Subject: FW: Y/97/18/DOC Land off Burndell Road, Yapton (discharge of conditions associated with Y/19/16/OUT)

We have an application in to discharge condition 19 – “Prior to the commencement of the development details showing the proposed location of one fire hydrant shall be submitted to and approved in writing by the Local Planning Authority. The fire hydrant shall be provided in accordance with the approved details before the first occupation of the development and shall be retained thereafter.”

Proposed location of F/Hyd.

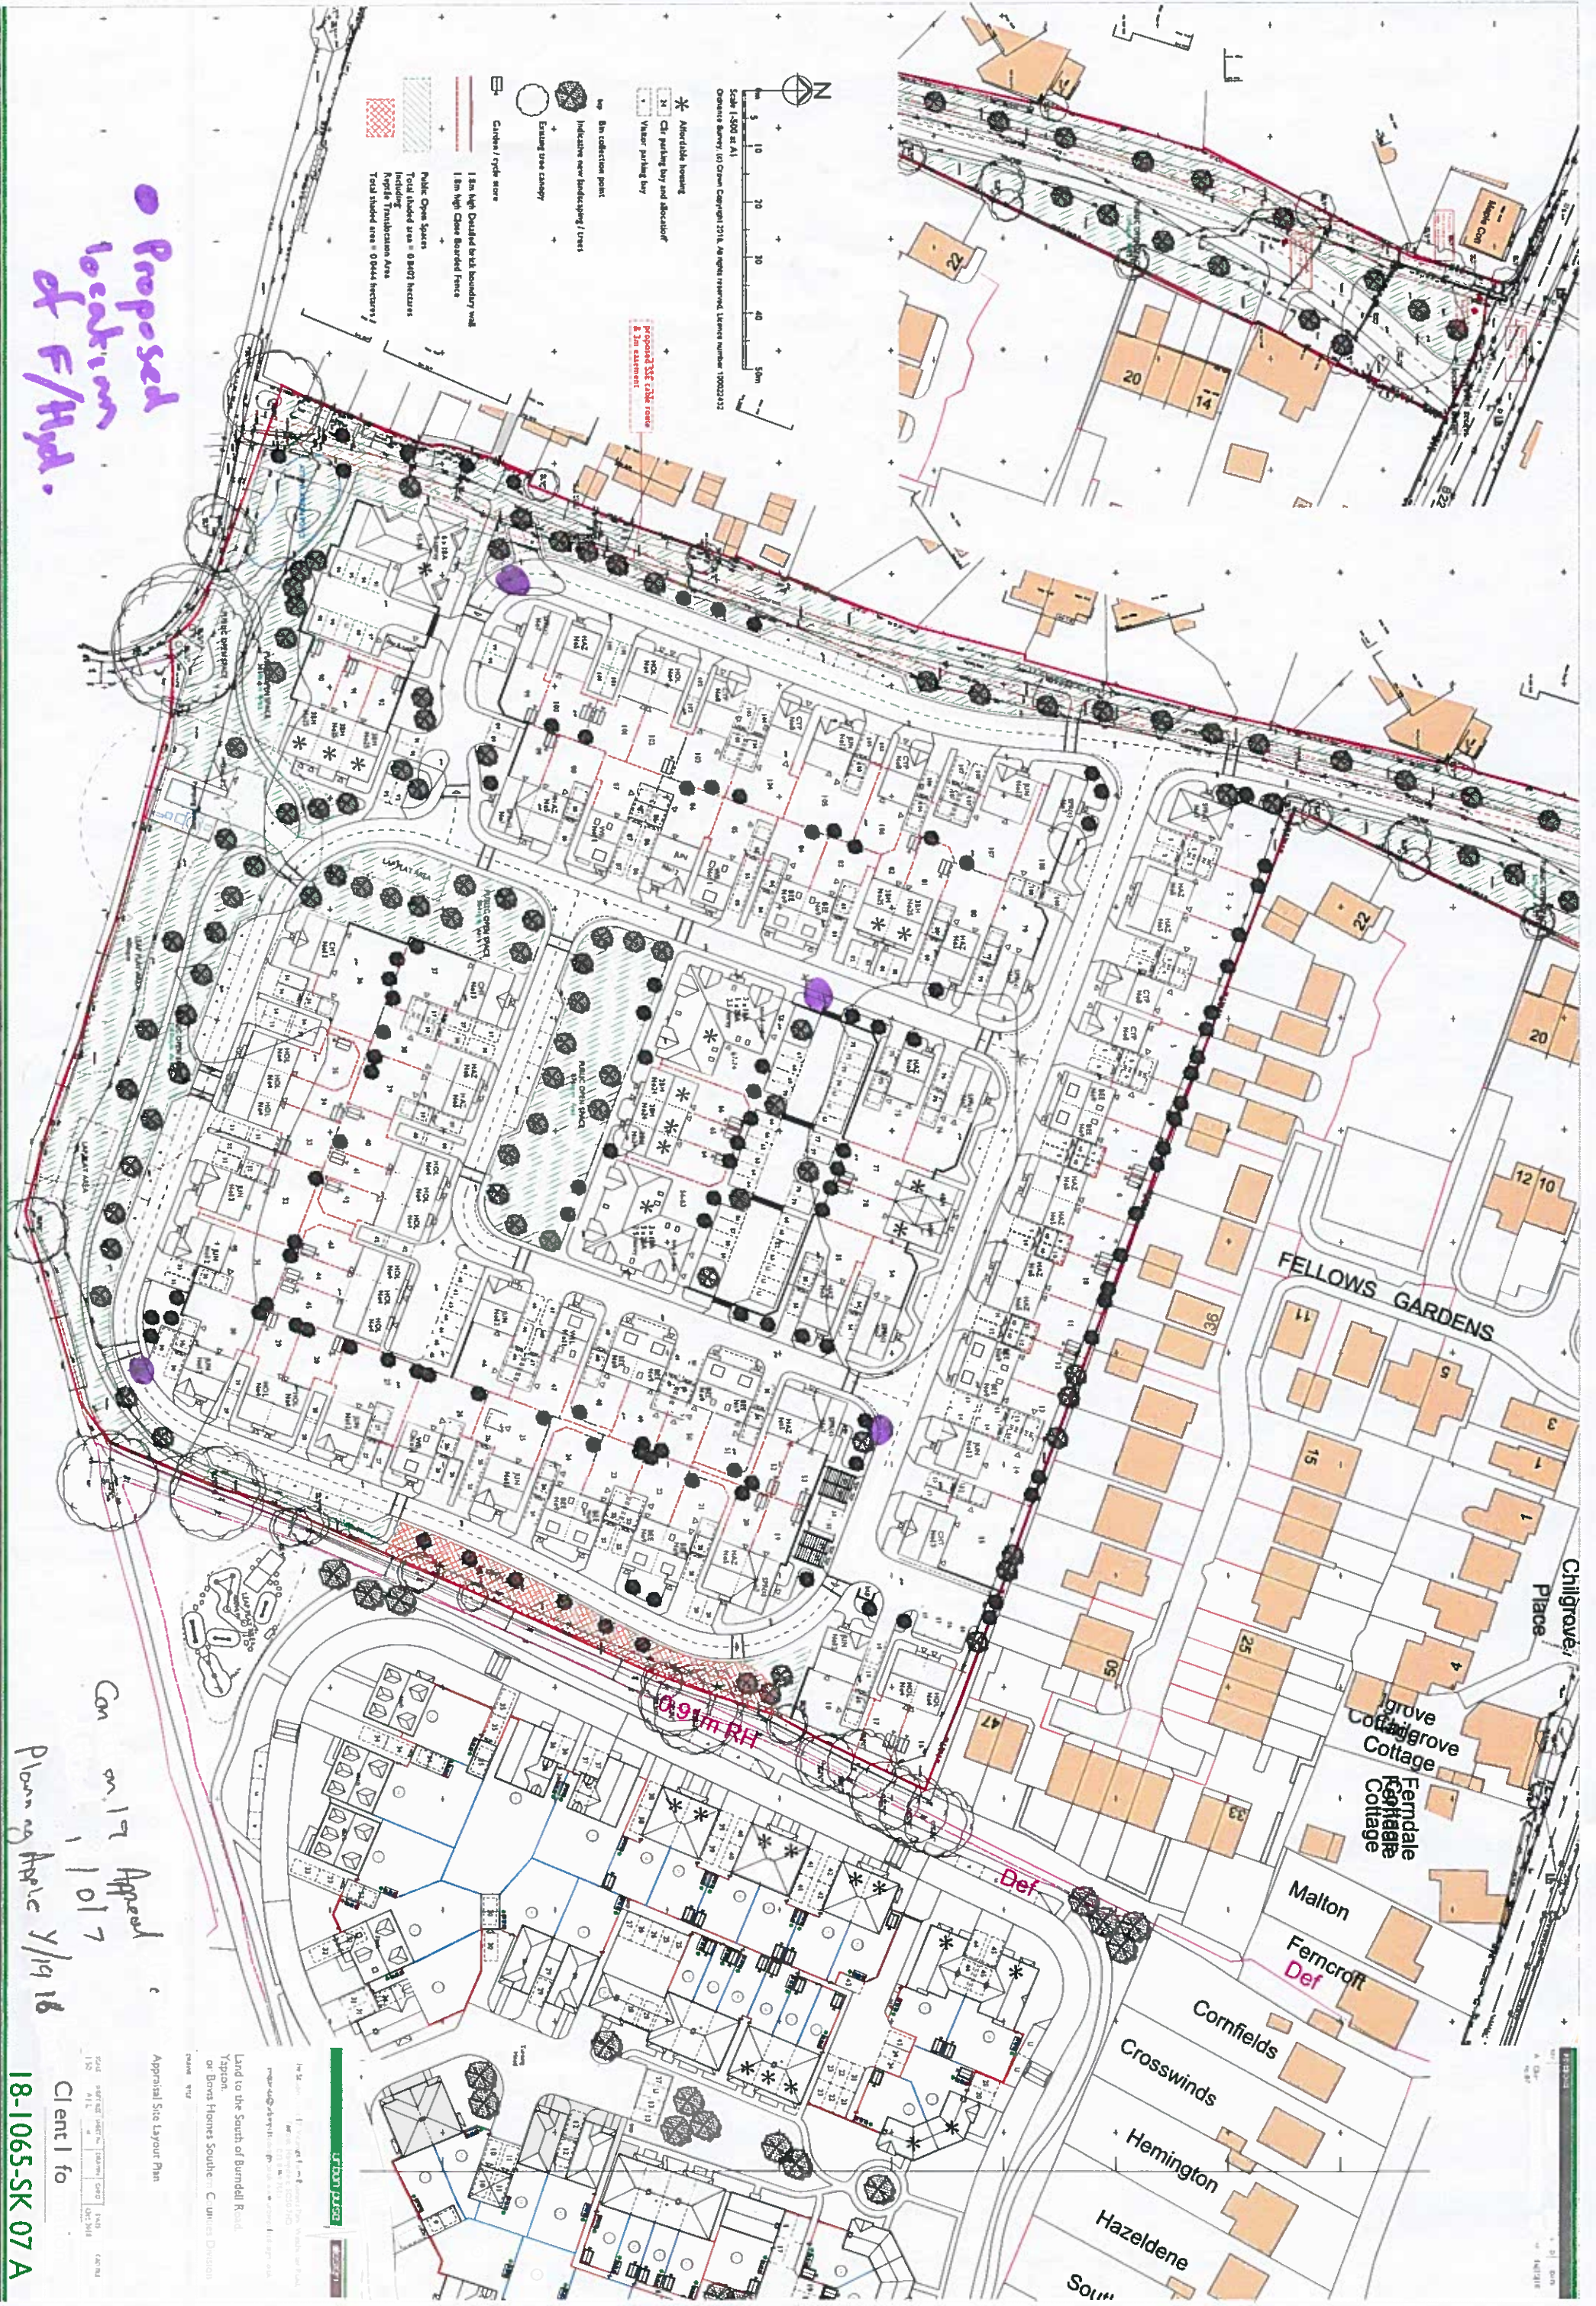
Please see email below and attachments. The fire hydrant locations are different to your plans. Therefore, can you confirm this is acceptable and if so, amend your fire hydrant plan and resubmit it.

Thank you for the information below. Just to update you we have already been in consultation with the Water Undertaker (Portsmouth Water) and agreed that the installation will include 3 hydrants located as attached. This will be sufficient to firefight the developments final layout.

This will release the first section of the condition (supply of agreed plans) and as this is an estate the first hydrant should be installed prior to the first occupation the rest will develop

as the site progresses until all hydrants are installed fit for purpose. When this stage is reached the whole condition can be released.
